RFI

RFI #: 17
Date: 12/29/2011
Job: EB-02 Keller Springs Lofts
Phone: 877-777-5115

Subject: Draft Stops

<p>4144 N. Central Expy. Suite B55 Dallas, TX 75204 214.520.8878 bgoarchitects.com</p>	<p>CONSTRUCTION ISSUE 10-17-2011</p>	<p>REVISIONS</p>	<p>KELLER SPRINGS LOFTS</p> <p>LOFT APARTMENTS IN ADDISON, TEXAS</p>			<p>DATE 08-05-2011</p>	<p>SHEET NUMBER 3.5</p>
			<p>10-17-2011</p>	<p>PROJECT 11129</p>

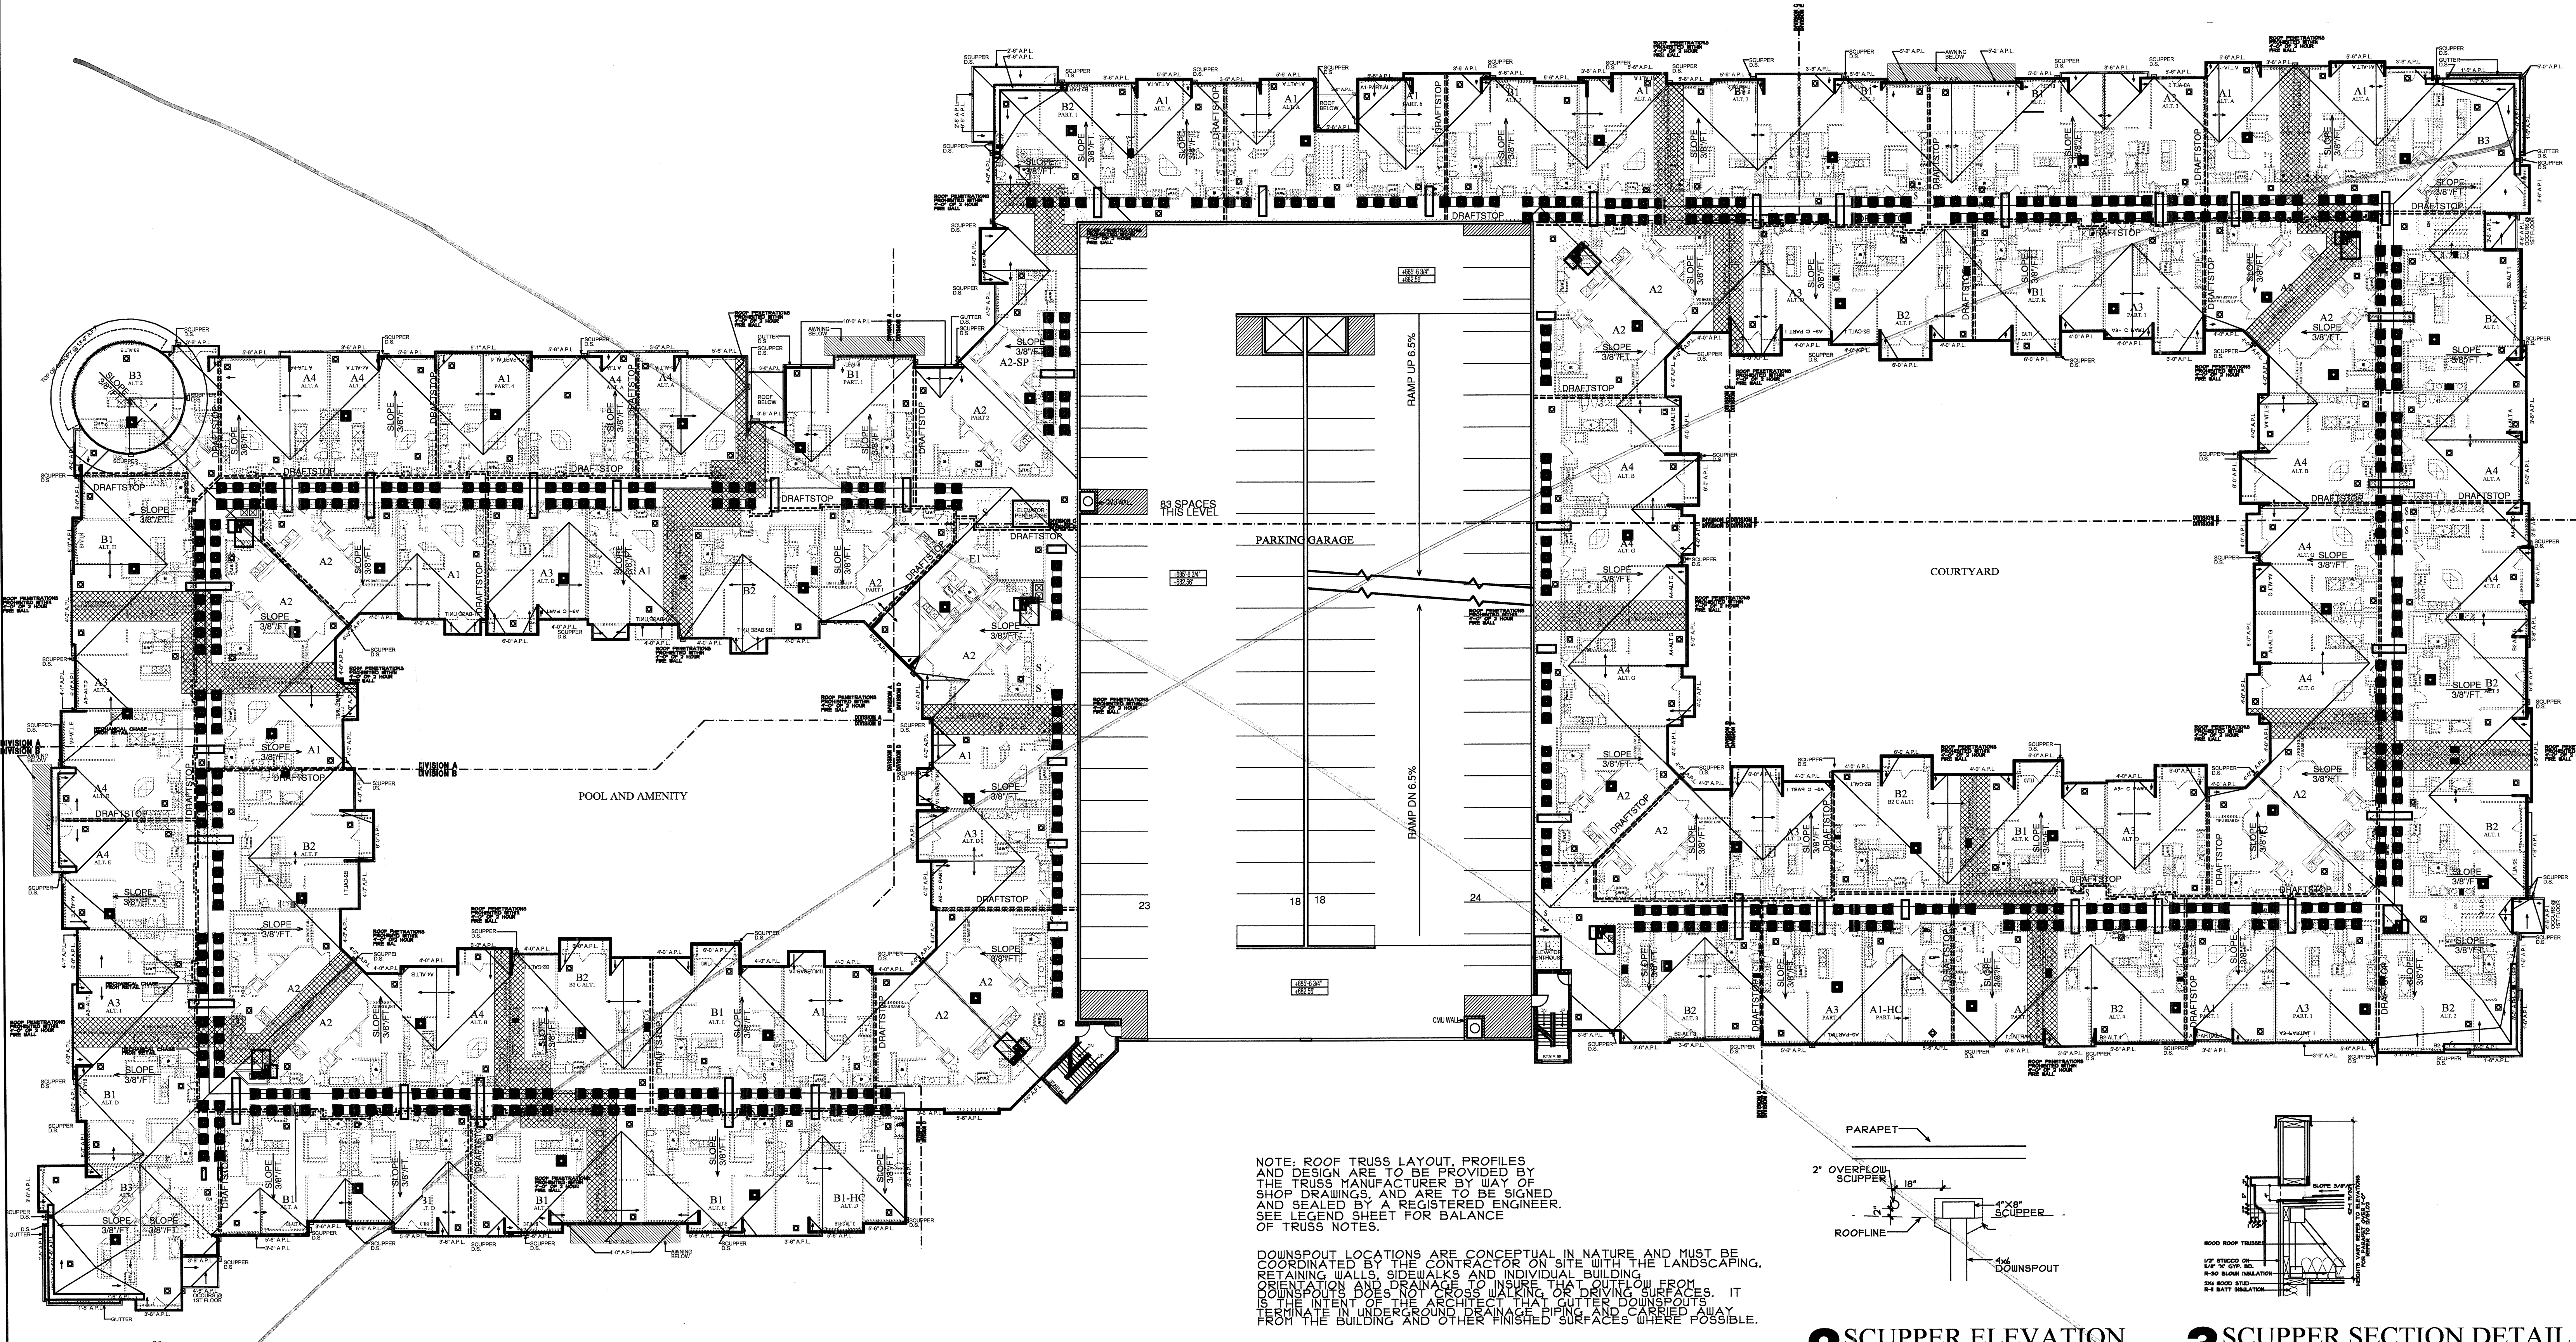
Drawing: 3.5 through 3.6 Spec Section:
Cost Impact: None Schedule Impact: None

Are attic draft stop still required even with a fully sprinkled attic?

Response:
Yes you are correct. Please refer to sheet 1.0A for the overall code analysis. Section 717 states the requirements for draftstopping and exception #2 states draftstopping is not required when the combustible spaces is sprinkled.
